Application no: 18/00459/DISC

Proposal: Discharge of condition 7 (Means of access to highway) 8 (internal access) 9 (driveways etc) of 14/02156/OUT

Location: Land South Of Cotefield Business Park Phase 2 Adj To Blossom Field Road Bodicote

Transport Development Control

REV. No.	DATE	DESCRIPTION	INITIALS
Client		<b>CREST NICHOLSON</b>	
Project		Bodicote, Banbury	
Title		Access General Arrangement – Oxford Road to Site	
Scale		1:1250 @A3	
Checked		KTG	
Date		Sept' 2018	
Drawn		AJW	
Drawing No.		5692:P504	
Rev		-

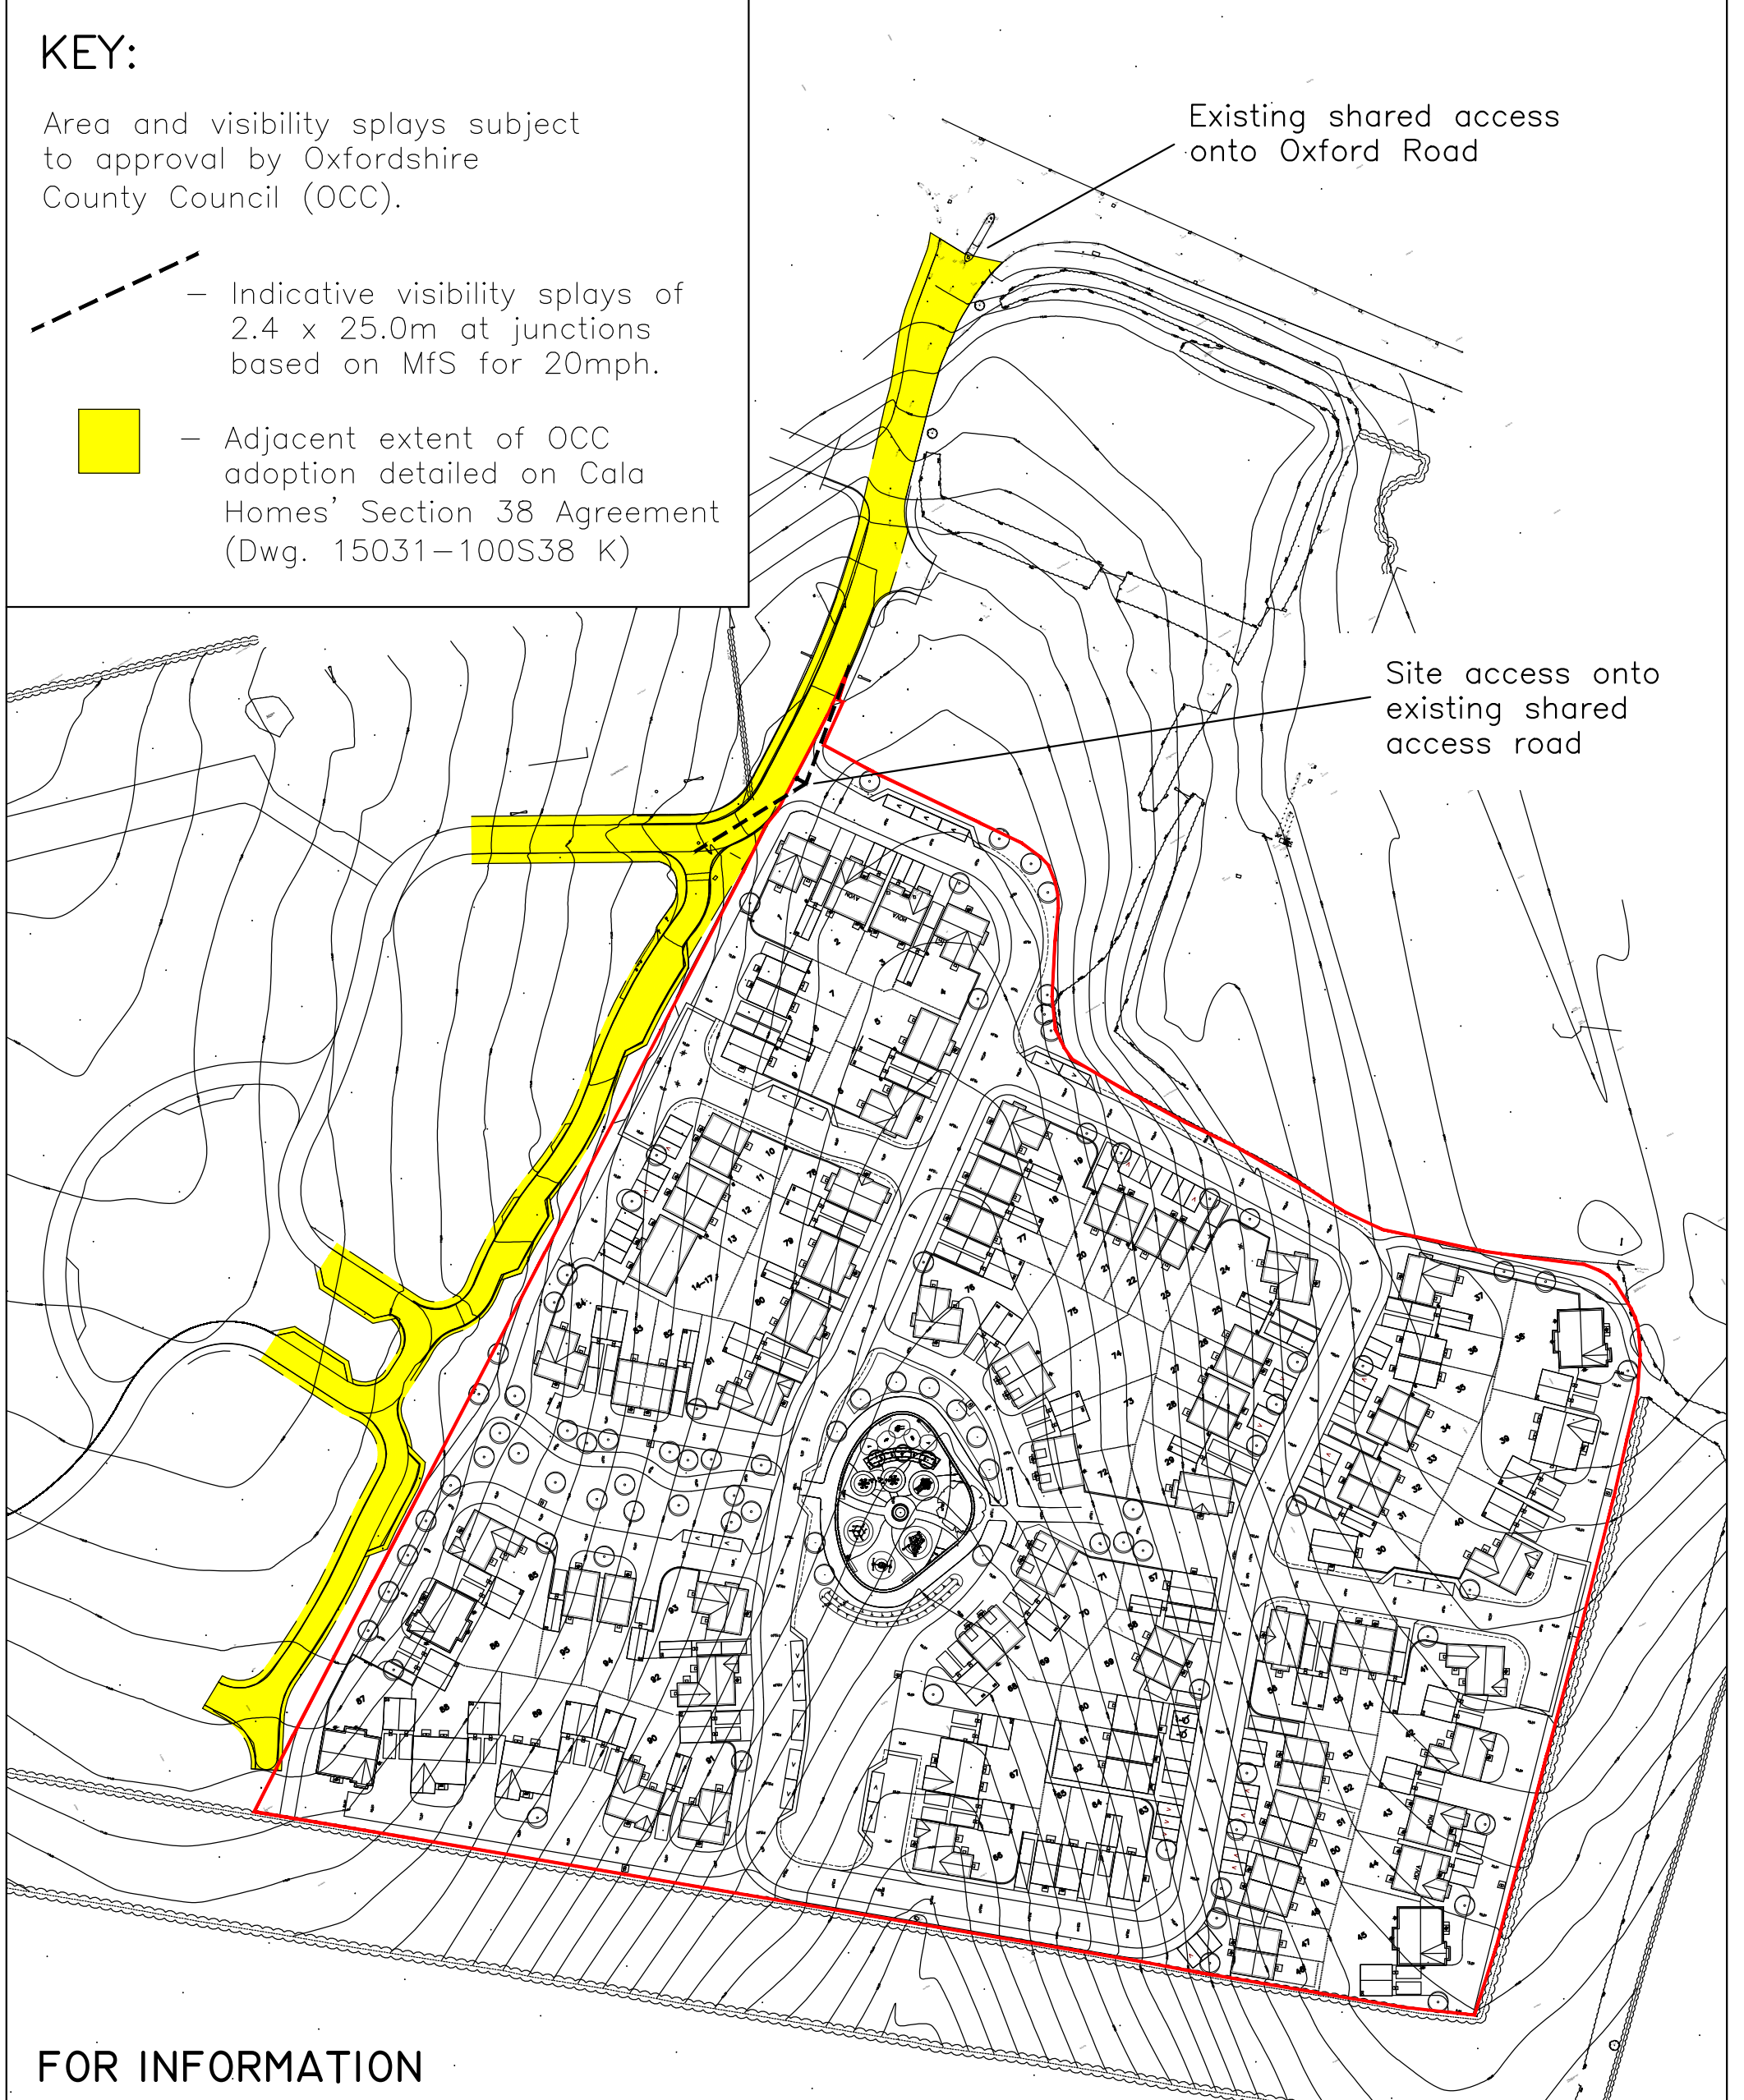
Condition 7 – Means of access to highway – No objection subject to the Section 38 and 278 processes.

Road Agreements are satisfied with the means of access details as submitted with this application for condition 7 subject to the Section 38 and 278 processes.

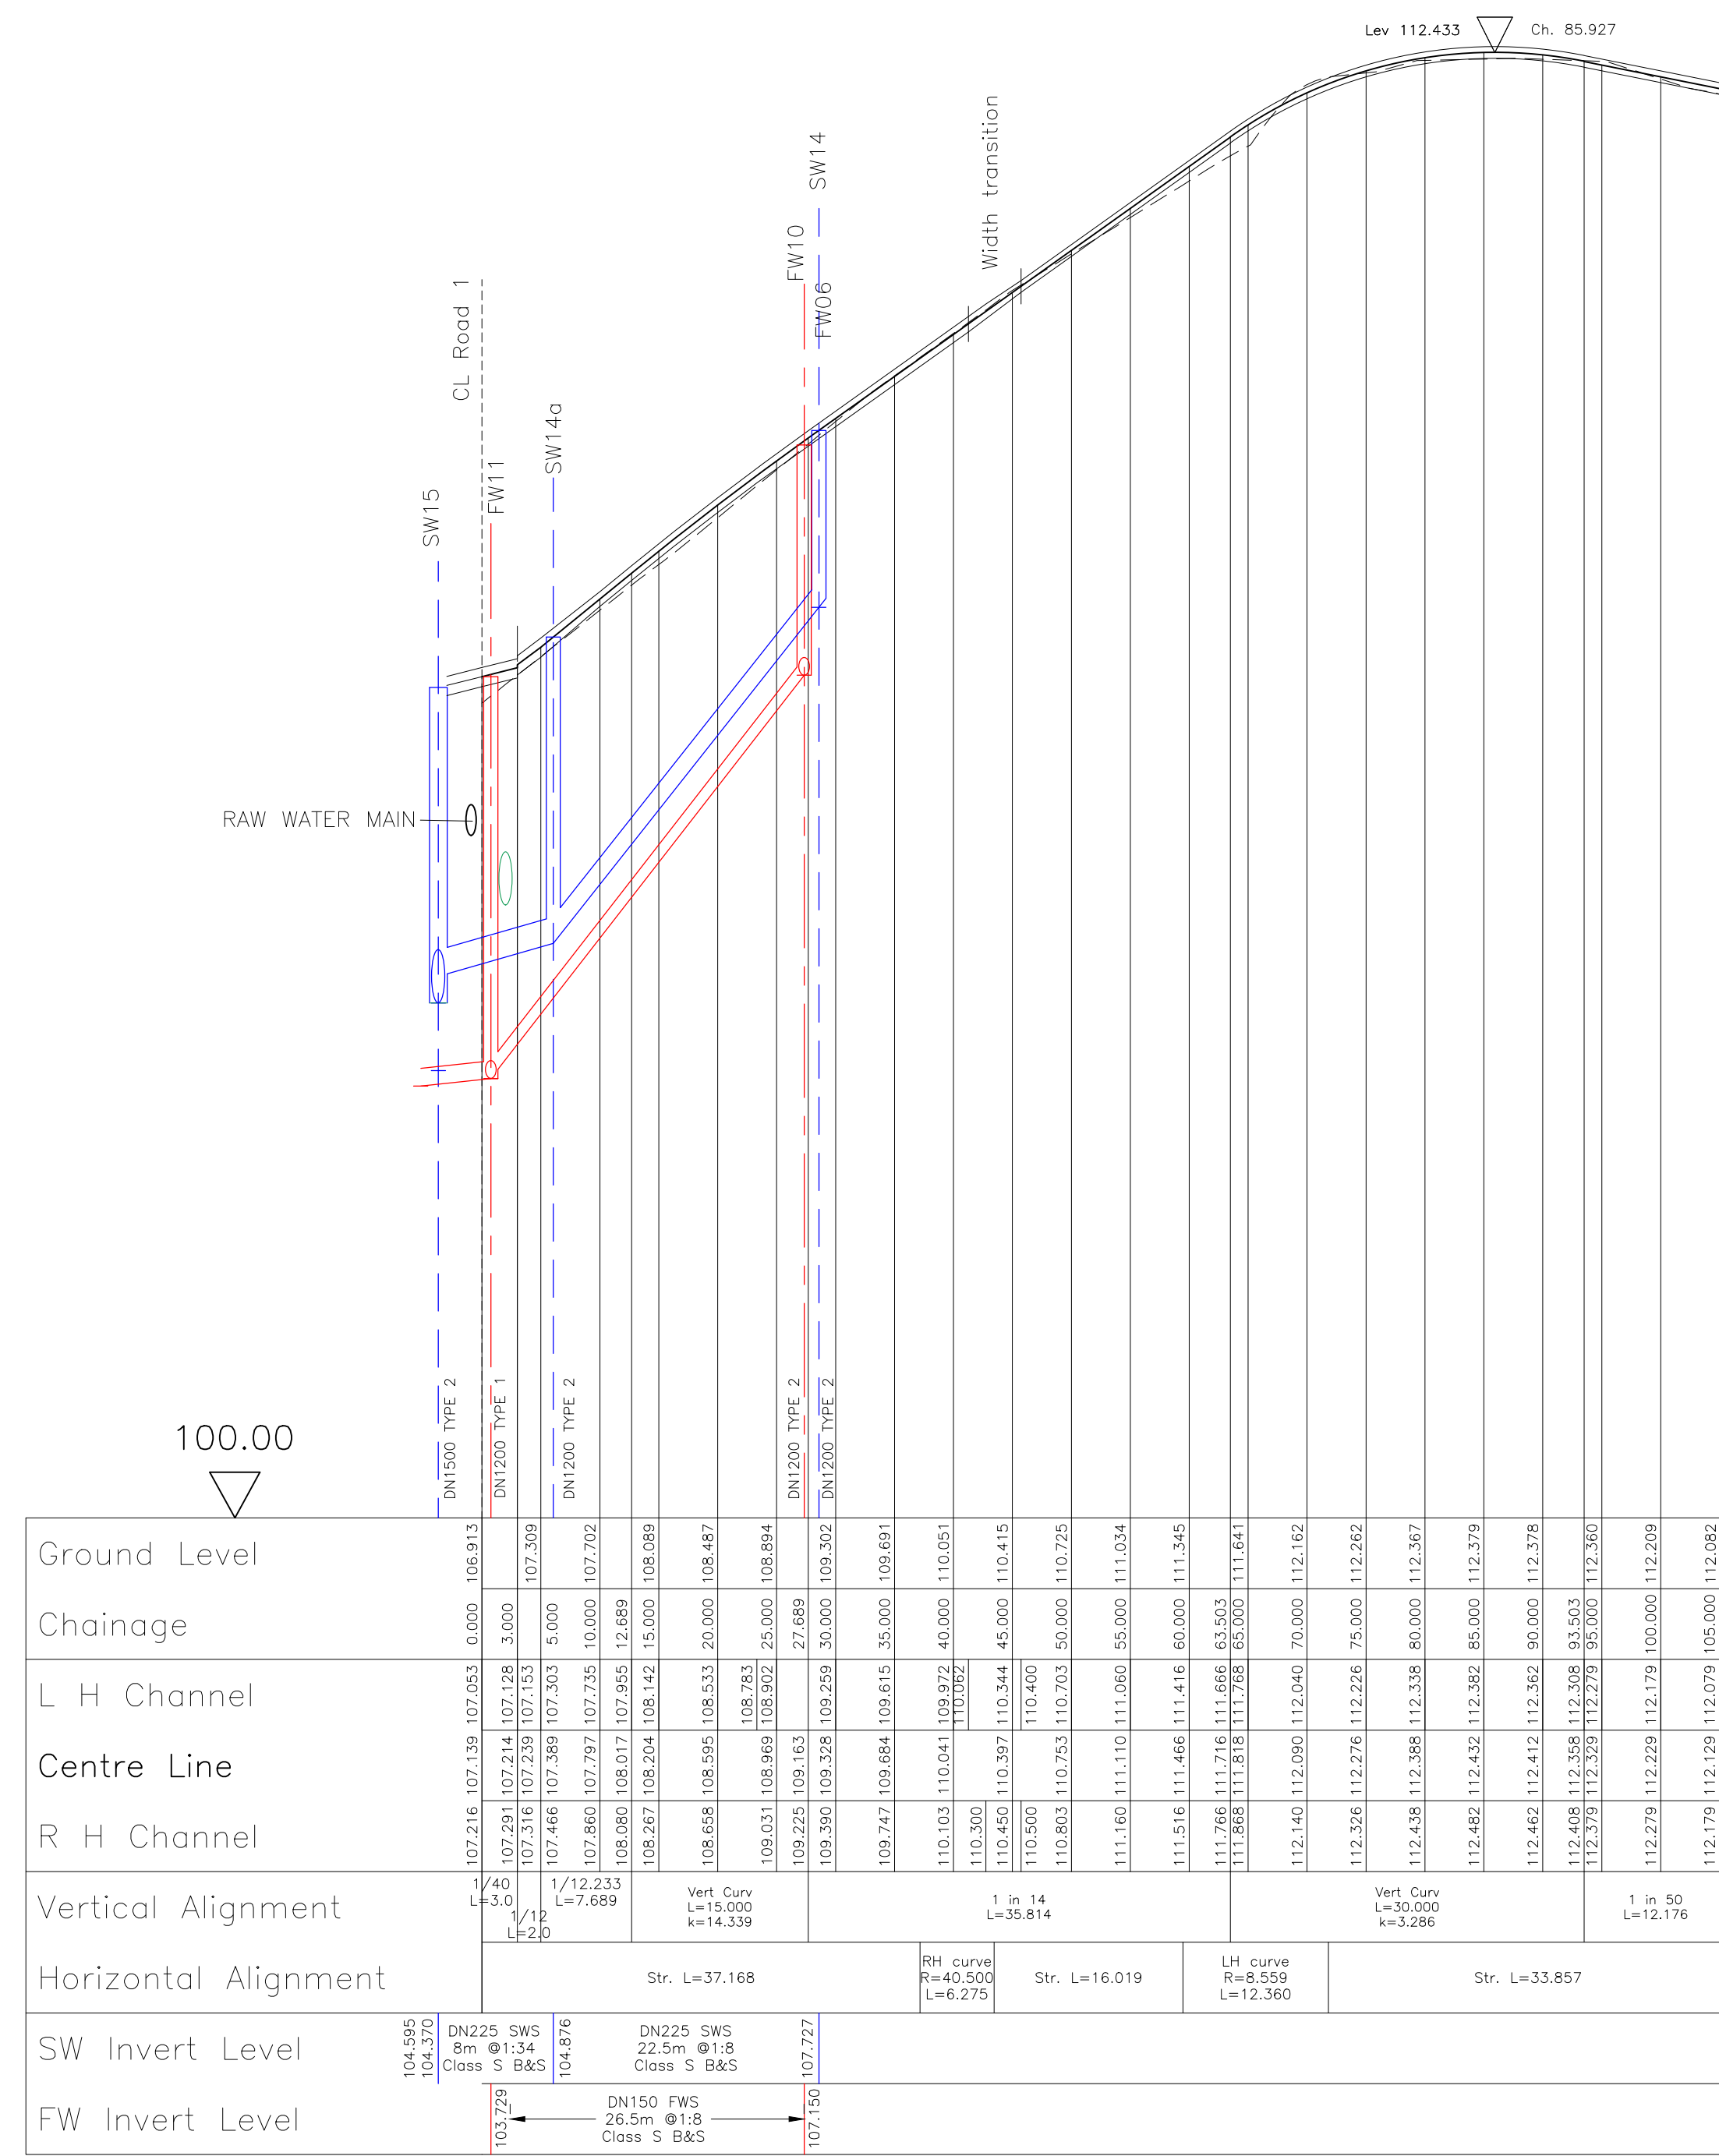
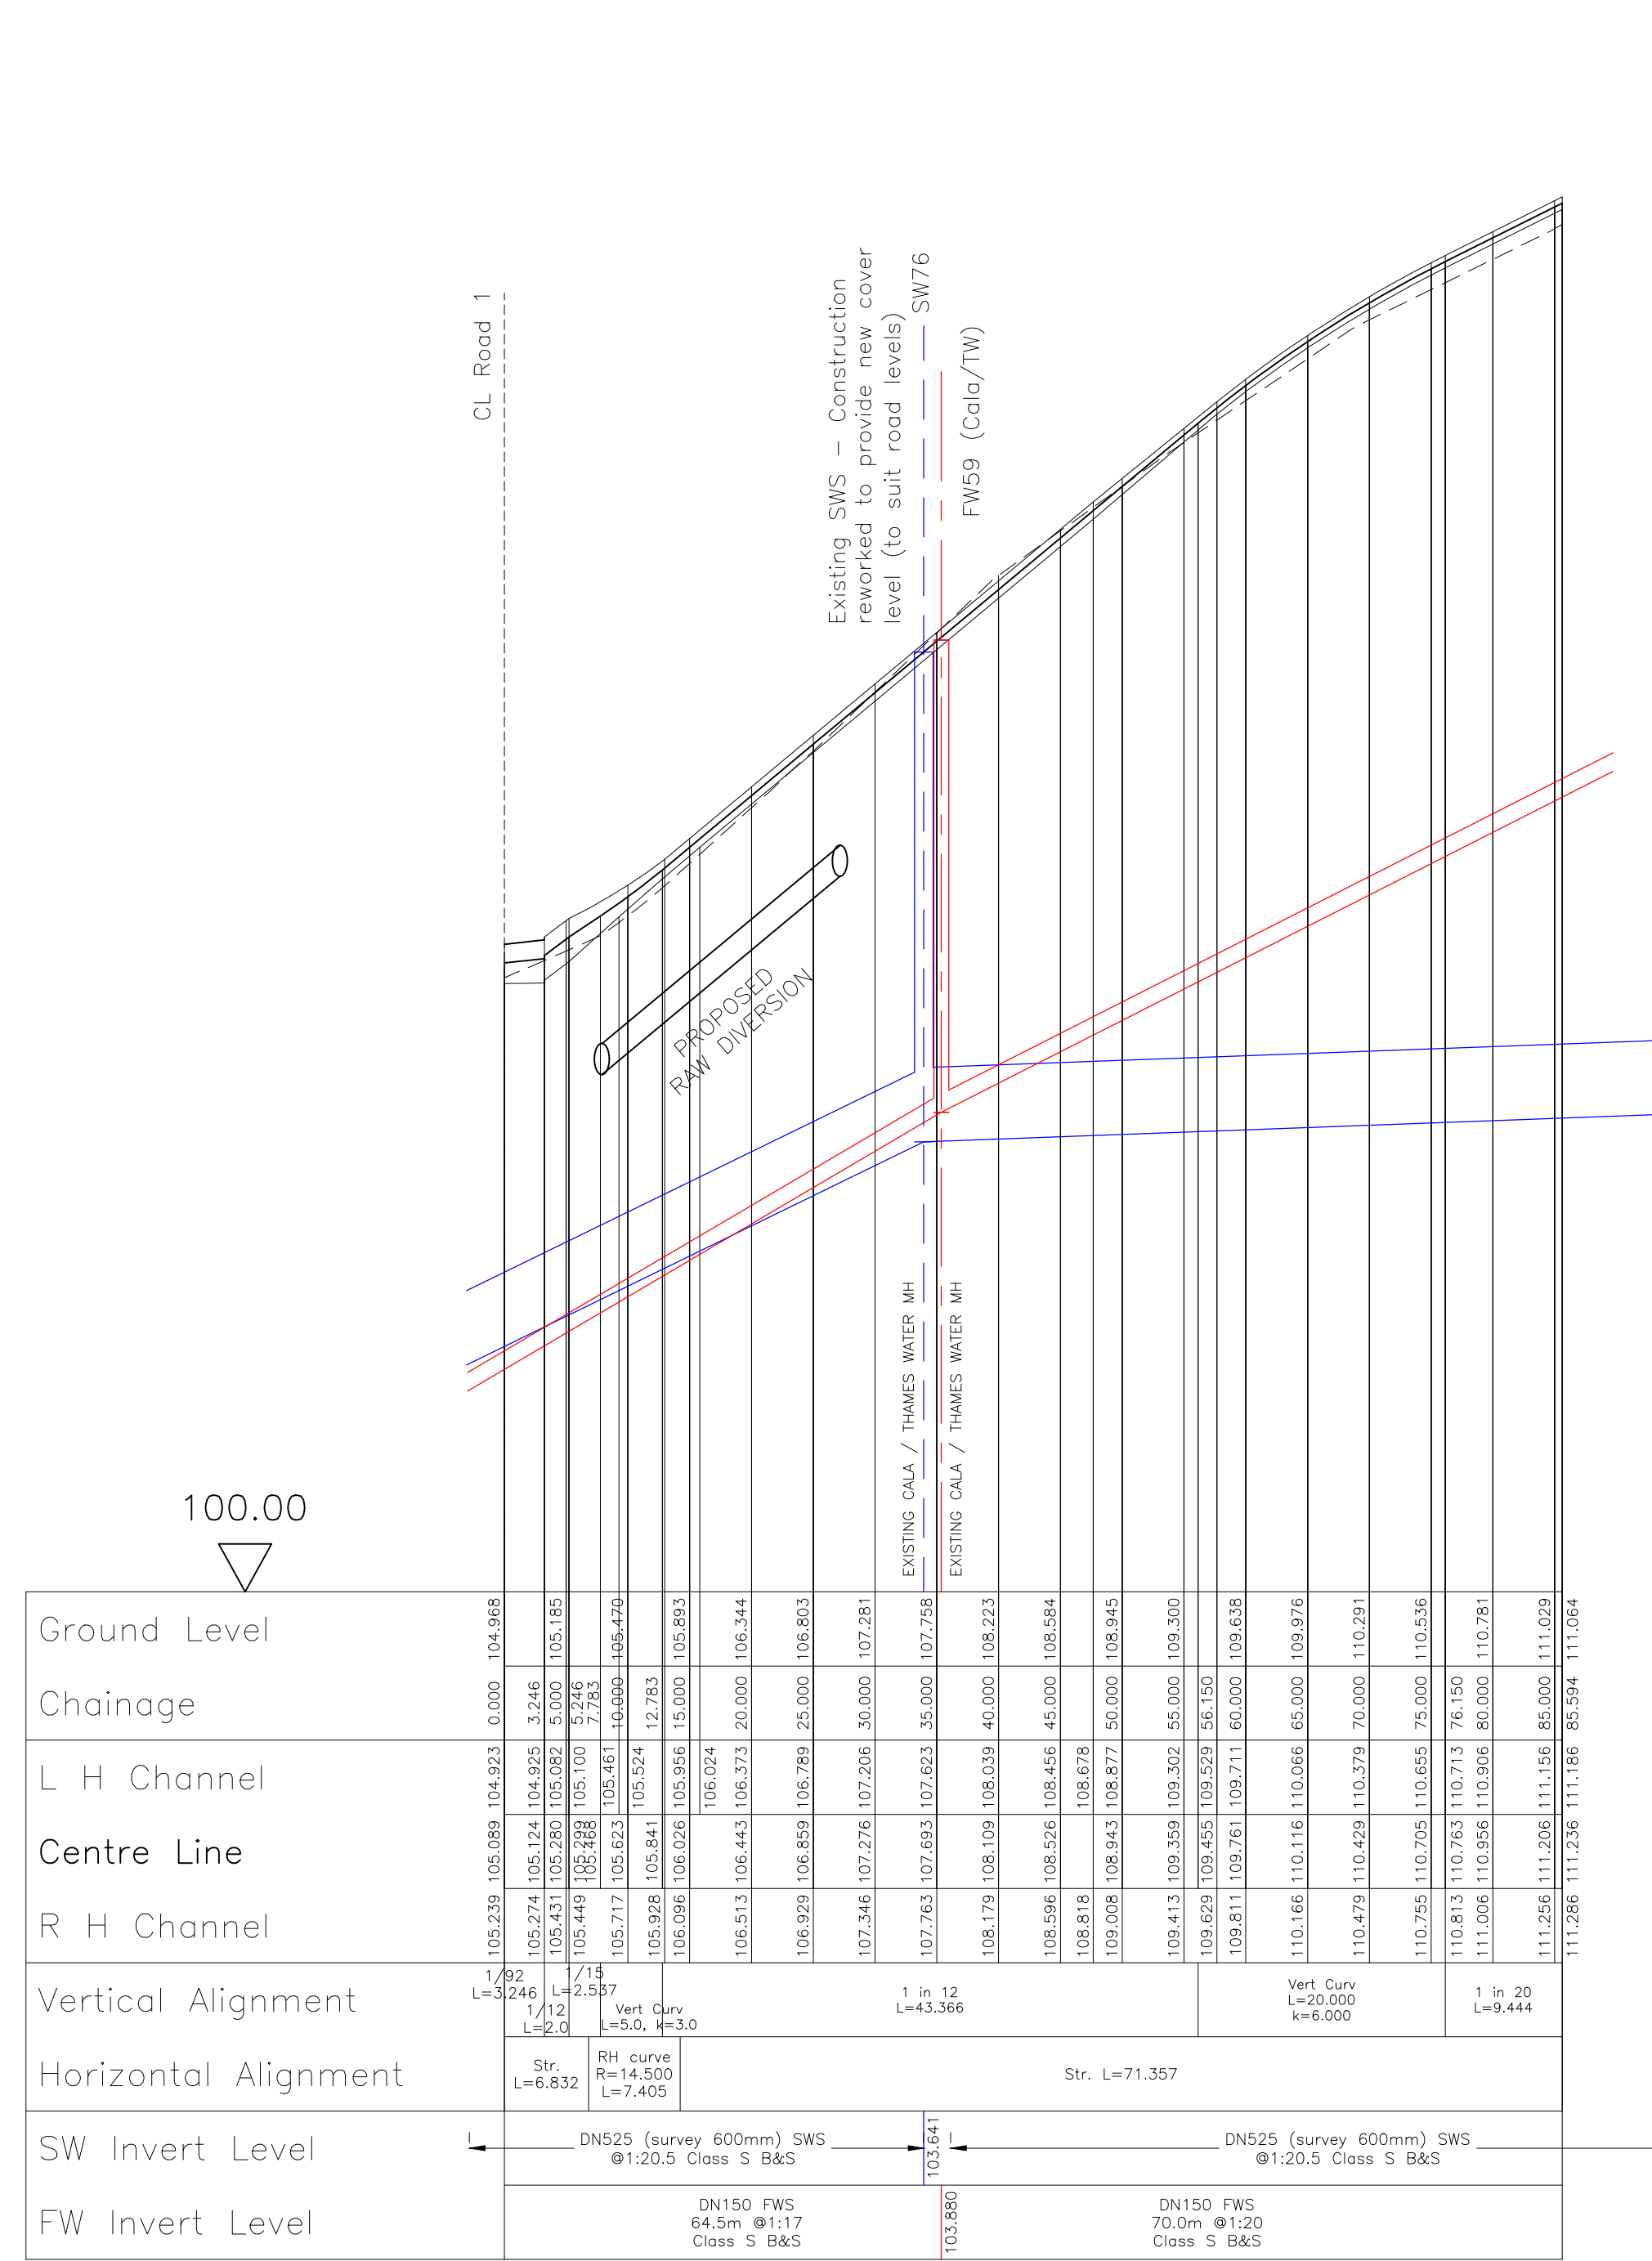
Condition 8 – Internal access – Objection, issues with ground levels.

However, the remaining conditions are a cause for concerns at present for Road Agreements due to the ground levels of the site and this is still currently being determined with them as to how these details can be resolved satisfactorily via the Section 38 audit process.

Please direct the applicant to liaise directly with OCC Road Agreements via the following email address - RoadAgreements@Oxfordshire.gov.uk in order to reach an agreement as how to proceed accordingly.
